WEST SUSSEX COUNTY COUNCIL CONSULTATION

TO:	Arun District Council - FAO: M Tomalova
FROM:	WSCC - Highways Authority
DATE:	17 February 2021
LOCATION:	Land West Of Fontwell Avenue, Eastergate, PO20 3RU
SUBJECT:	AL/9/21/DOC Approval of details reserved by condition imposed under ref AL/117/18/PL relating to Condition No 3 - Construction Management Plan.
RECOMMENDATION:	More Information

CMP plan

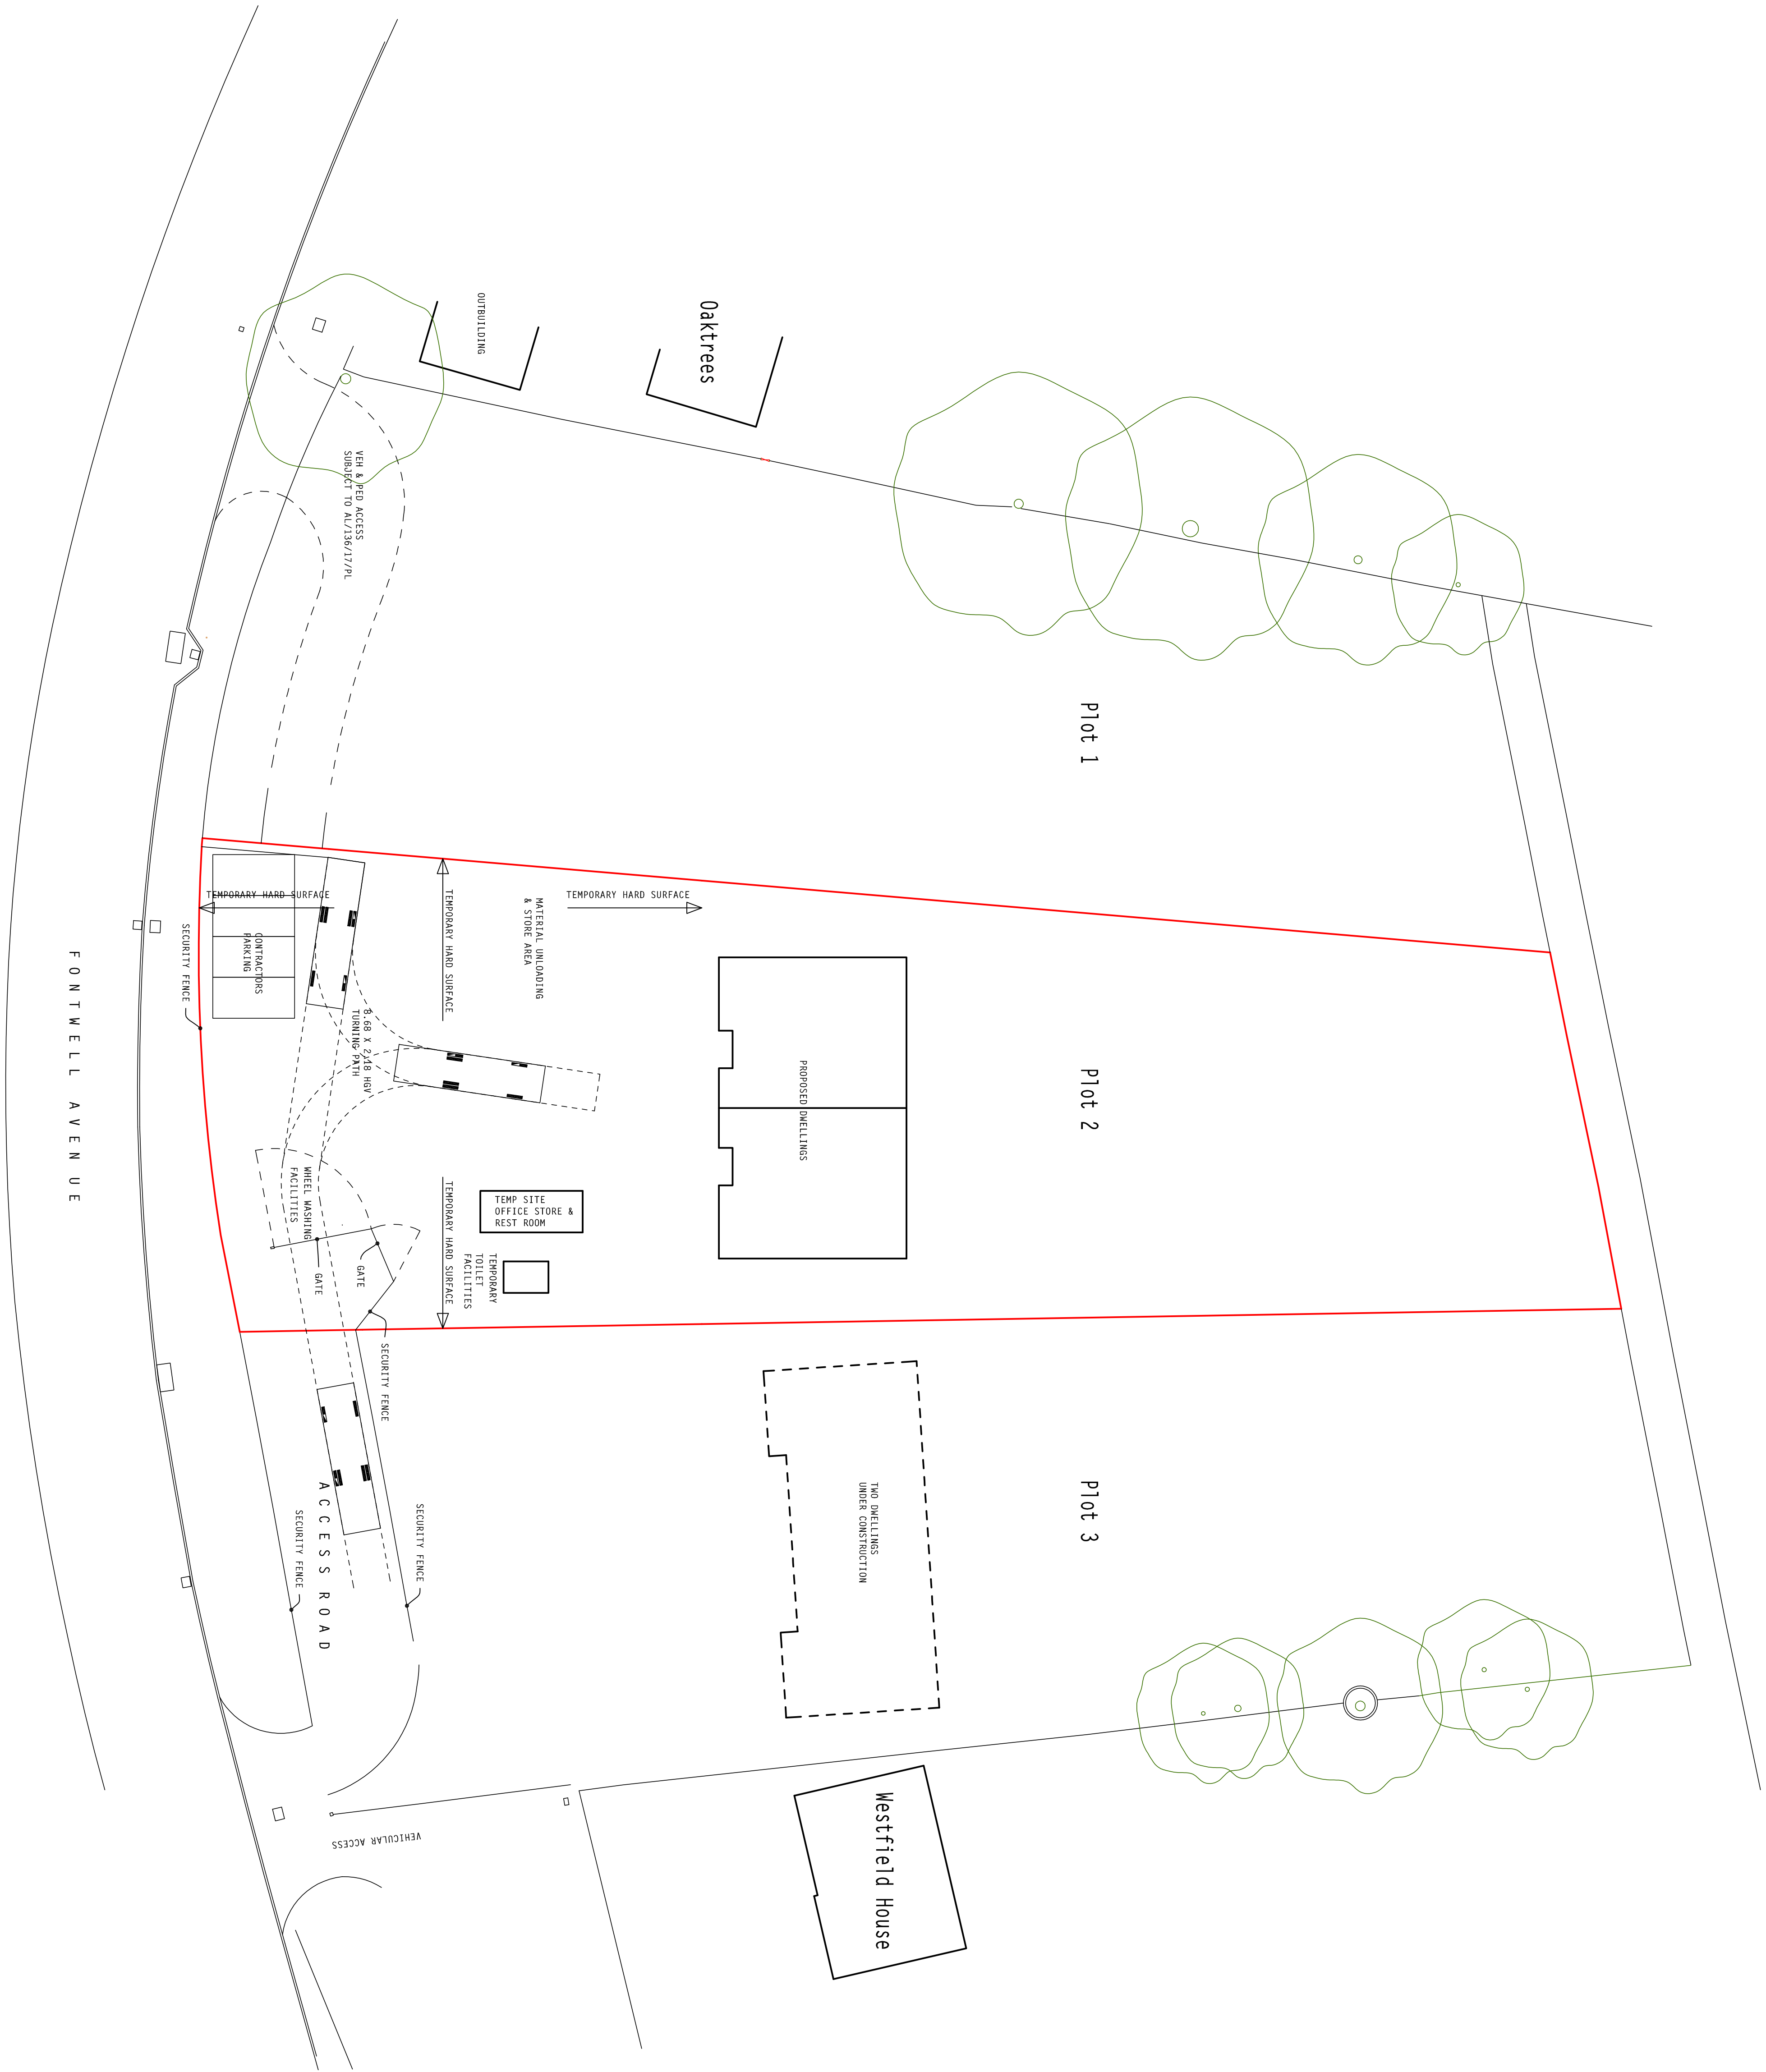
Anticipated number, frequency, types of vehicles - the CMP mentions that "no more than three lorries per day" maximum will be required. The access arrangements for the lorries should be clarified. Ideally the applicant should clarify the largest vehicle anticipated and demonstrate that access is suitable for this vehicle to enter the site and turn around on site in order to exit in a forward gear. Has an agreement been entered in to for the access works or will the existing access be used at this stage? If the two access points as proposed under AL/17/18 are not yet to be constructed then the applicant should demonstrate through swept path tracking plans that the existing access can accommodate anticipated vehicles.

Contractor parking - a site set up plan clearly indicating this should be provided.

Loading and unloading - as per comments above, a clear area for this should be marked on a site set up plan and it should be demonstrated through tracking plans that such vehicles can manoeuvre to this point and turn on site.

Storage of plant/material - a site set up plan clearly indicating this should be provided.

Wheel washing - Acknowledge that this will be provided though advise that the site set up plan clearly show this.
